ONE EARTH SOLAR FARM
EN010159

WEST LINDSEY DISTRICT COUNCIL

WLDC RESPONSES TO ExA's FIRST WRITTEN QUESTIONS

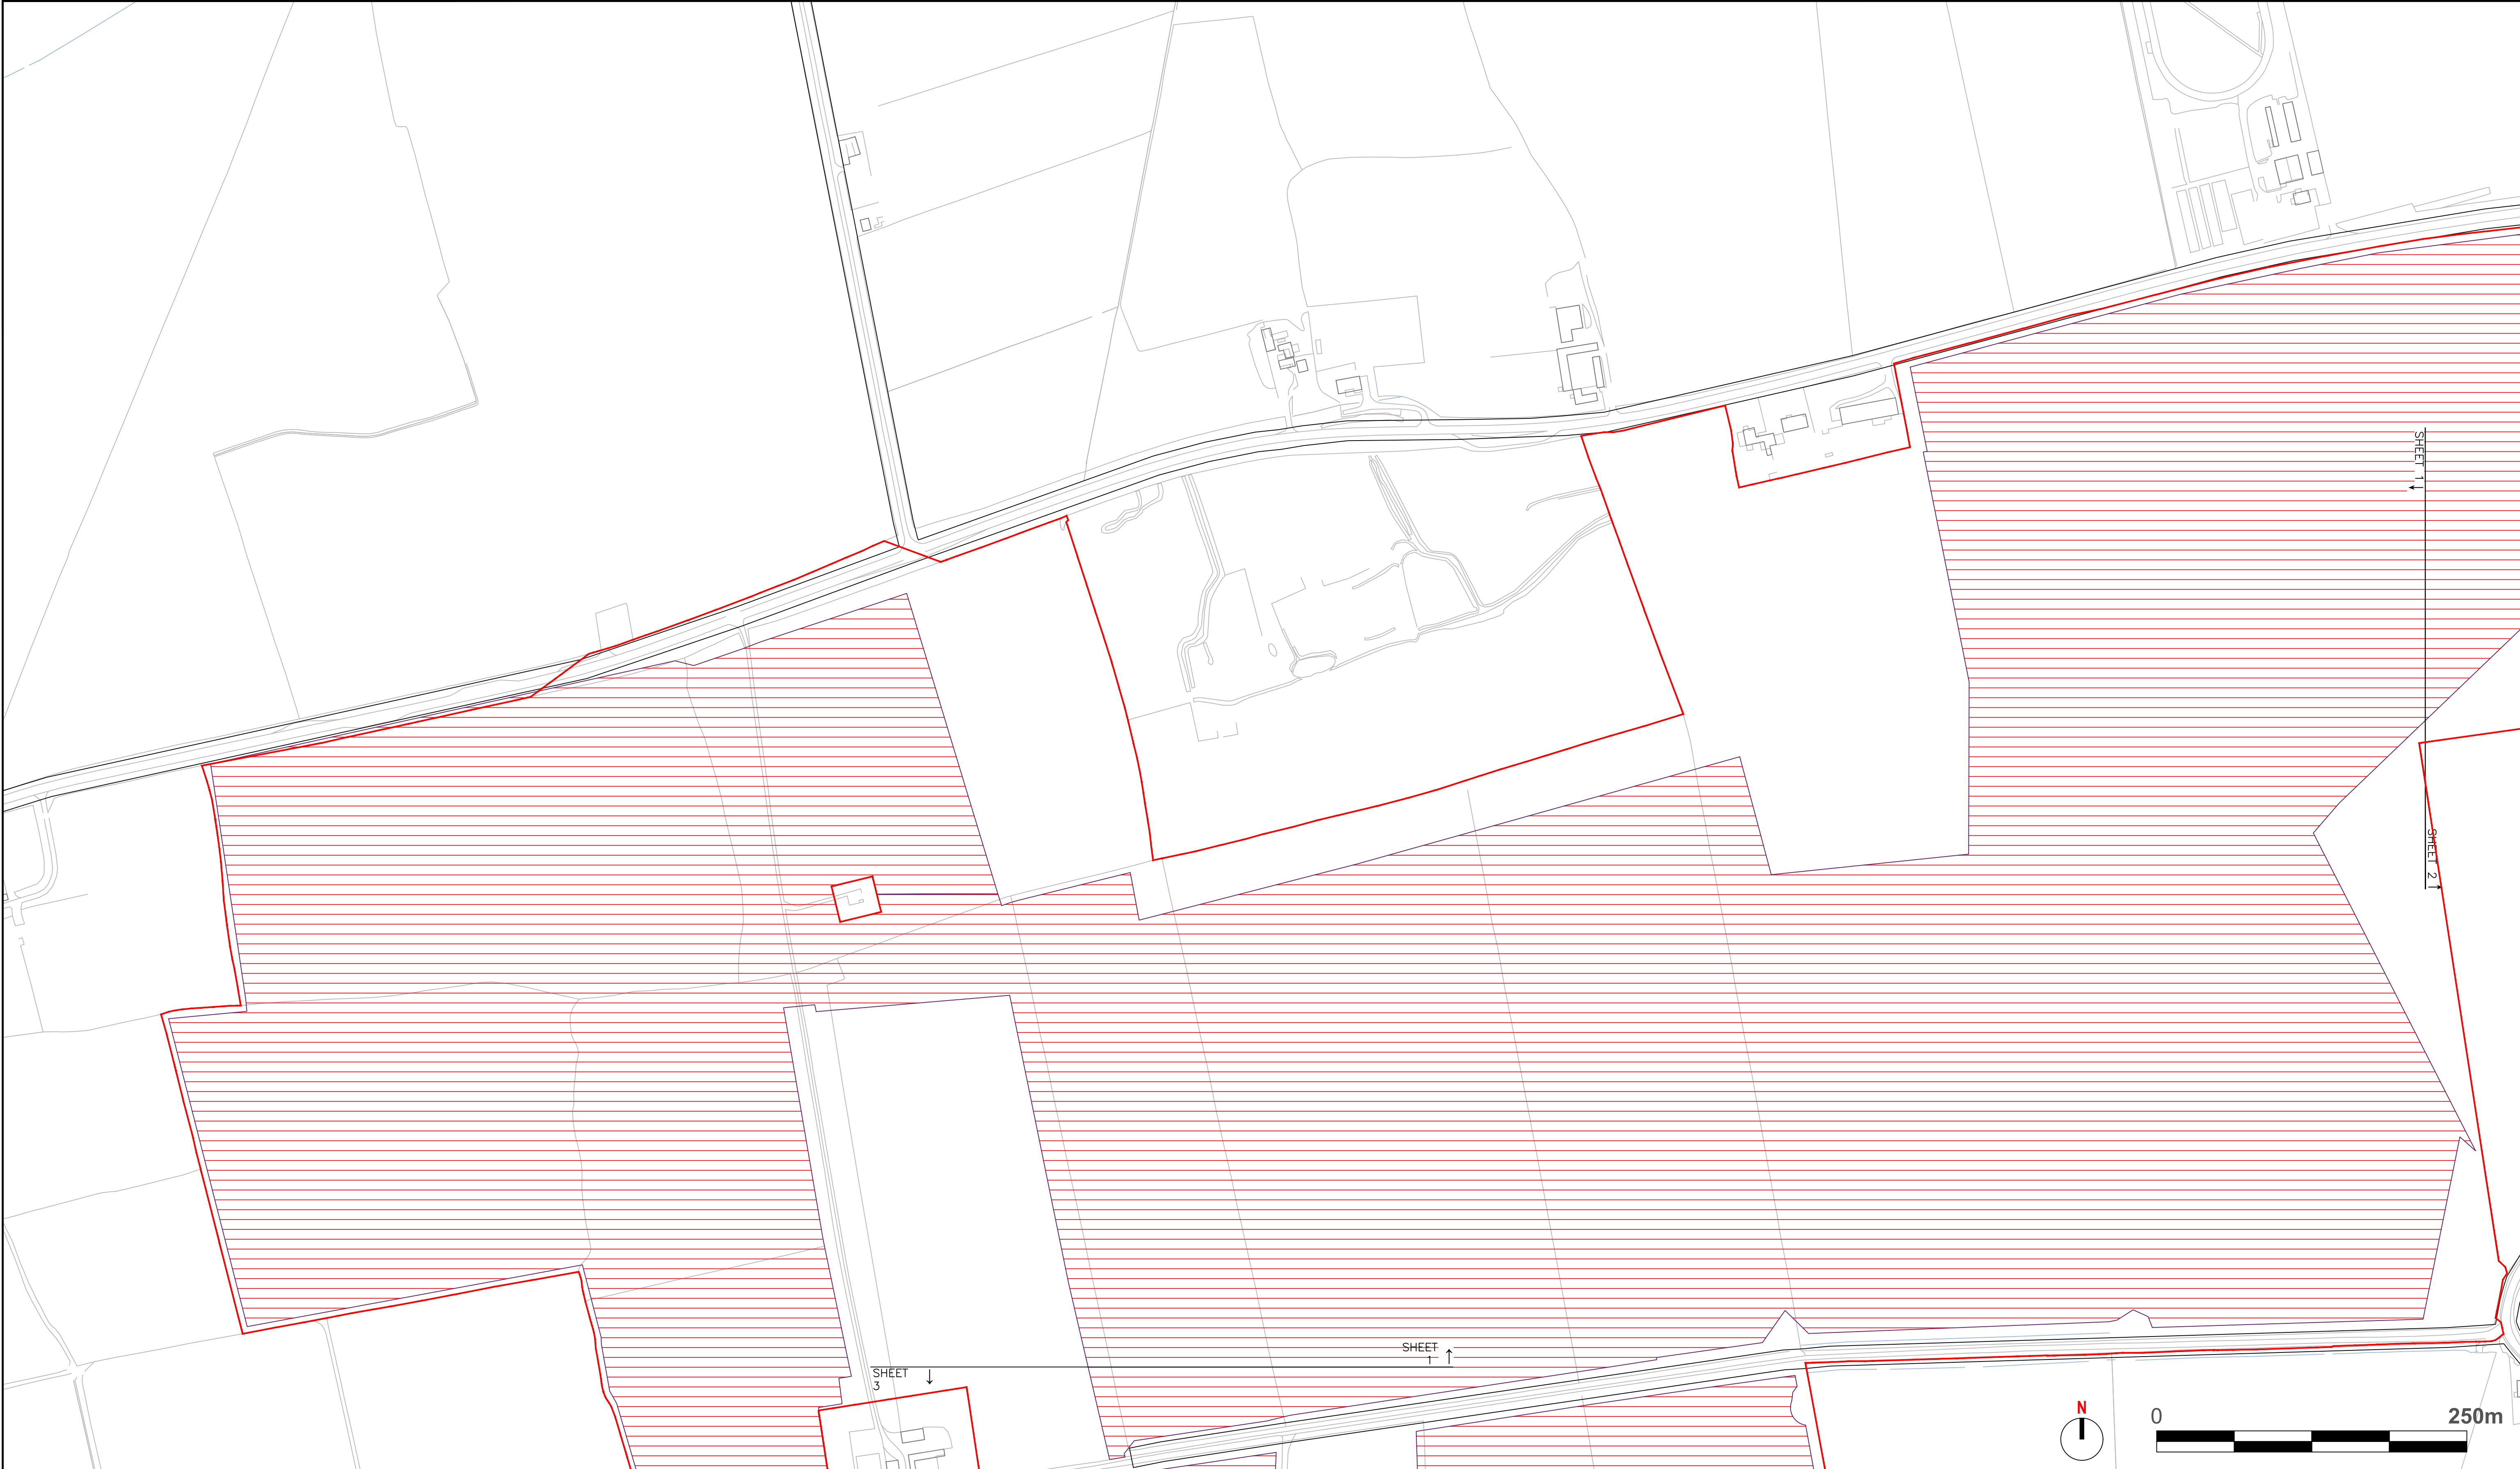
As set out in WLDC LIR, the height parameter plans [APP-016] show a maximum height of 13.5m across the “Substation/BESS location” which extends to an area of approximately 20 hectares. For scale, immediately northwest of the eastern BESS area is the existing 10m high Anglian Water building at the Hall Water Treatment Works. Without any information to the contrary, WLDC have to assume that the 13.5m maximum height indicated on the plans will extend across all of the BESS area and therefore that the BESS area would introduce a major new element in the countryside, akin to distribution warehousing.

Additionally, it is not clear from the application documentation whether or not there will be a substation in the area within WLDC defined on the height parameter plans [APP-016] as the “Substation/BESS location”, and, if there will be a substation, there is no information on its intended location.

(2) Given the potential for significant landscape and visual effects associated with a substantial 13.5m high structure potentially across 20 hectares in the “Substation/BESS location” the lack of clarity set out above does not provide WLDC with comfort that future consenting would meet landscape, visual and good design objectives.

(1) WLDC consider that it would be beneficial for all parties for these to be set out in a single document to be certified. The document should include locationally based parameters which set out the proposed location of key infrastructure such as substations and BESS infrastructure.
